via e-mail
Sheery Atkins
Onshore Consents Manager
Renewable Energy RES CPD
Equinor UK Ltd

Your Ref: SEP DEP REP3 DS / FRA Updates My Ref: FW2023_0408
Date: 16 May 2023 Tel No.: 0344 800 8020
Email: llfa@norfolk.gov.uk

Sheringham and Dudgeon Windfarm Extensions – Review of the Updated Onshore Substation Drainage Design and Study, Hydraulic Modelling and Flood Risk Assessment – Tracked Changes Versions (May 2023)

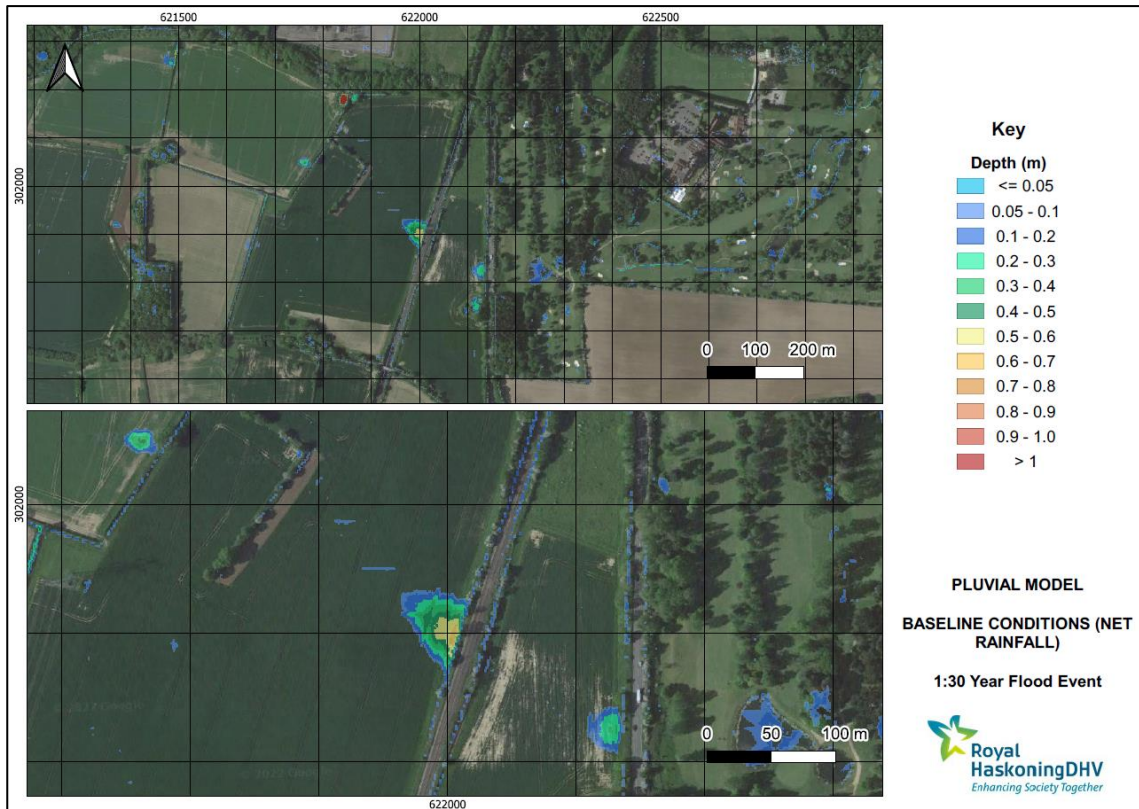
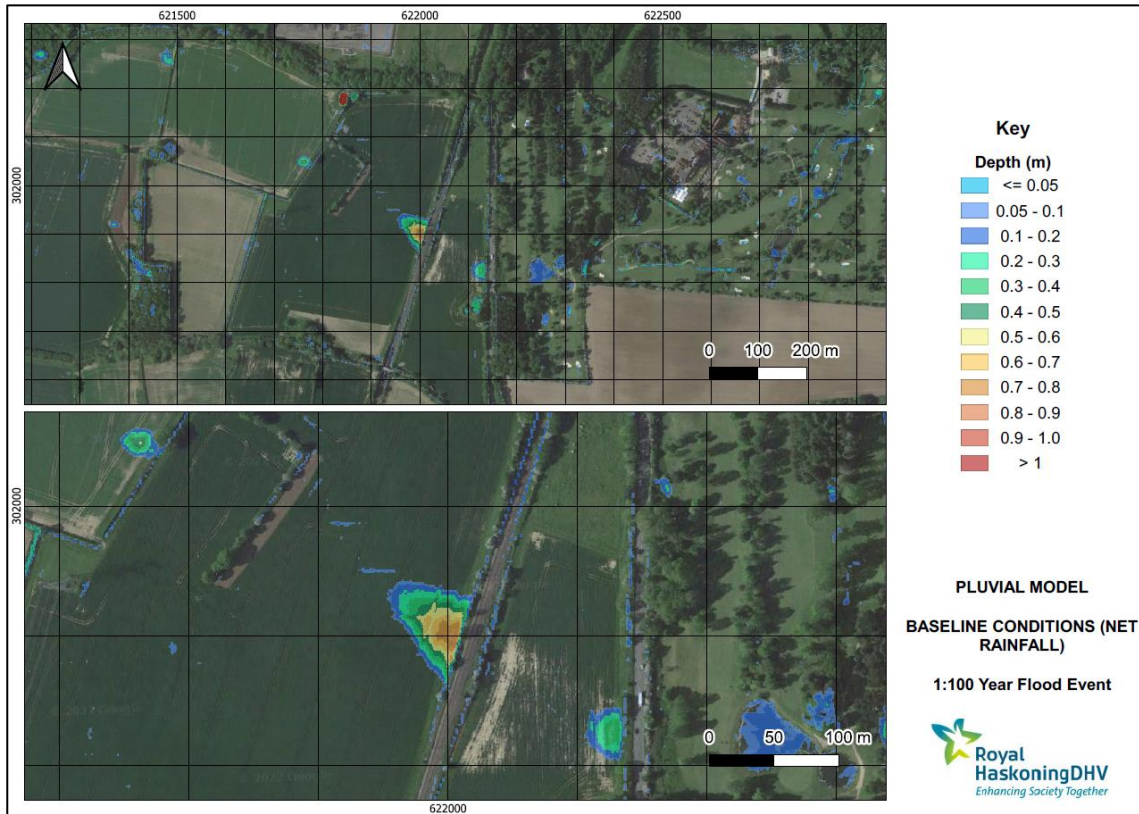
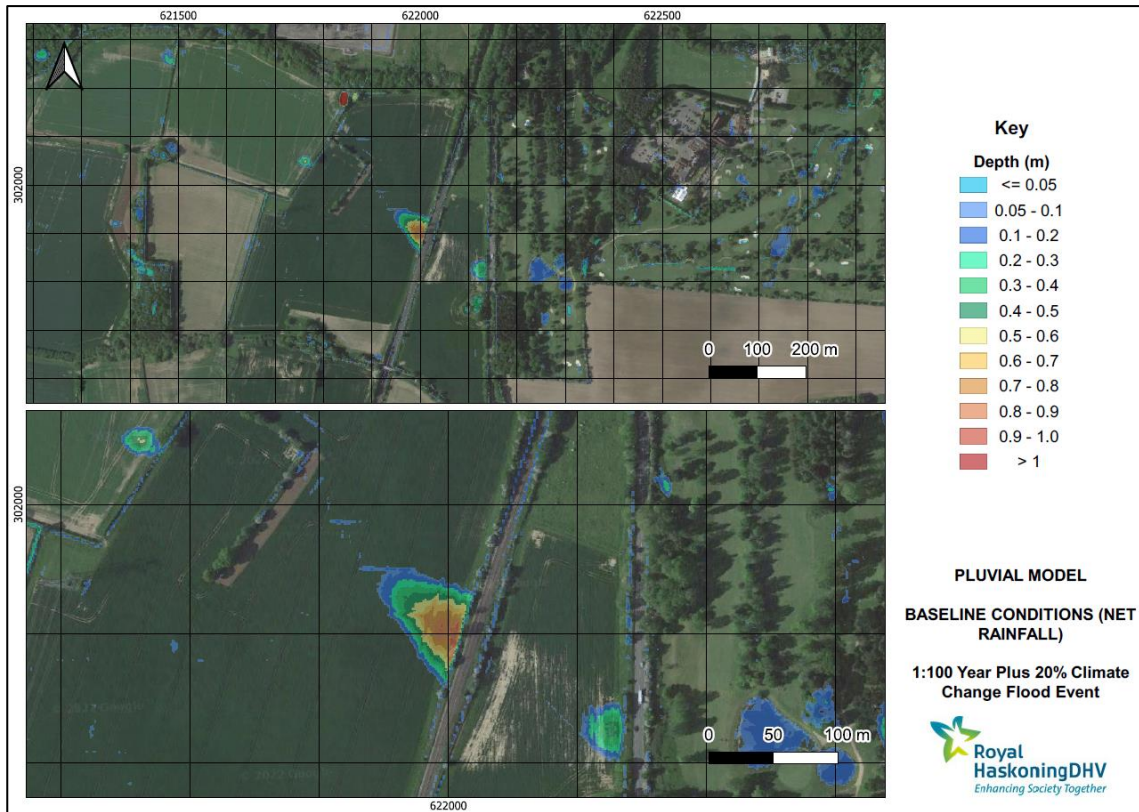
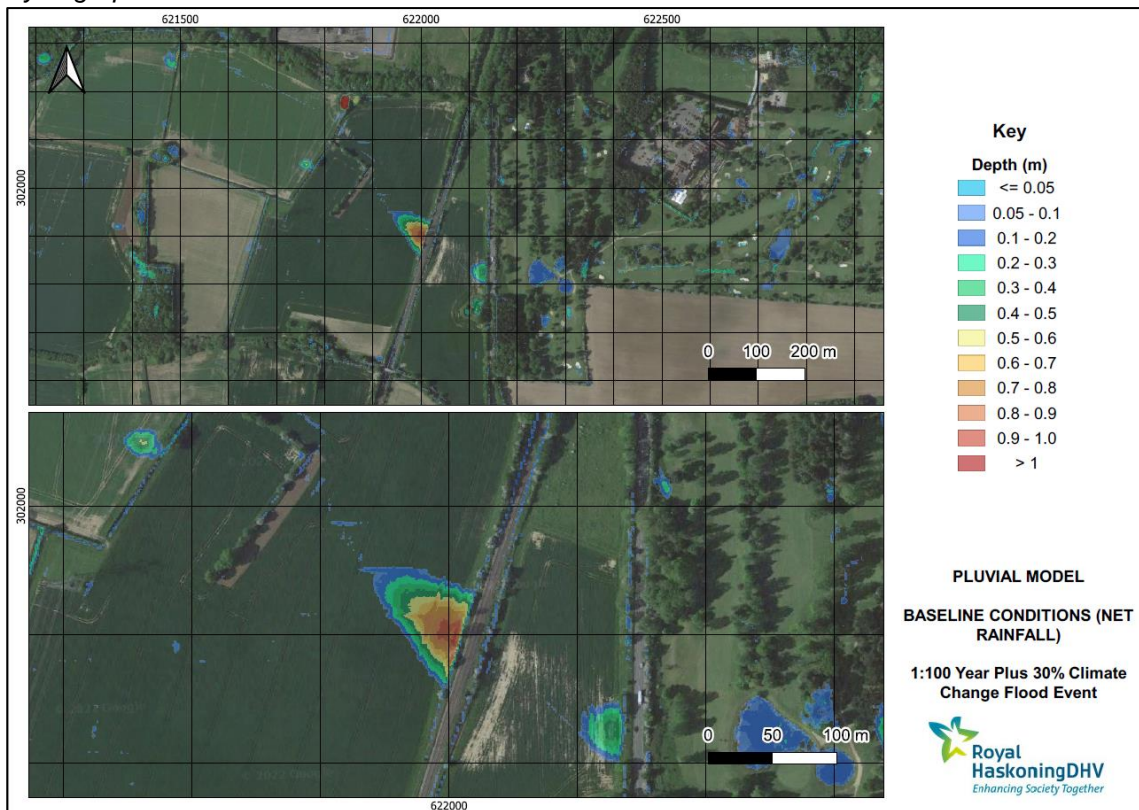
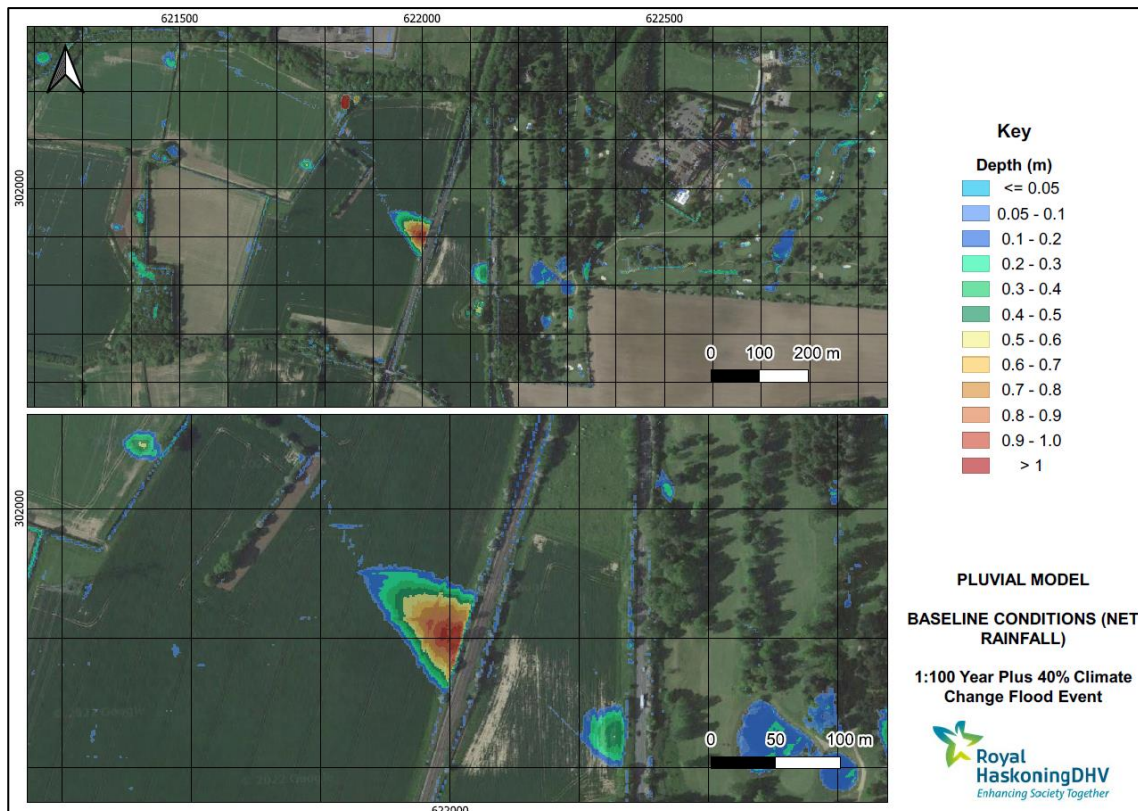
The LLFA is satisfied with the majority of our previous comments that have been addressed. The LLFA notes the applicant have not presented the results for the sensitivity testing of infiltration losses. Whilst the LLFA accepts the net rainfall approach, we would expect the applicant to present the gross rainfall results in a similar manner as to peak rainfall and roughness. This is so we can assess whether additional freeboards are required. At an initial re-review of the Flood Risk Assessment and the latest Addendum to the Flood Risk Assessment an assessment of indication of the freeboard to the applicant's water sensitive infrastructure and equipment was not observed. The importance of the sensitivity testing of infiltration losses depends on what freeboard is available before the infrastructure and equipment floods. **The LLFA requires further information to resolve this matter.**
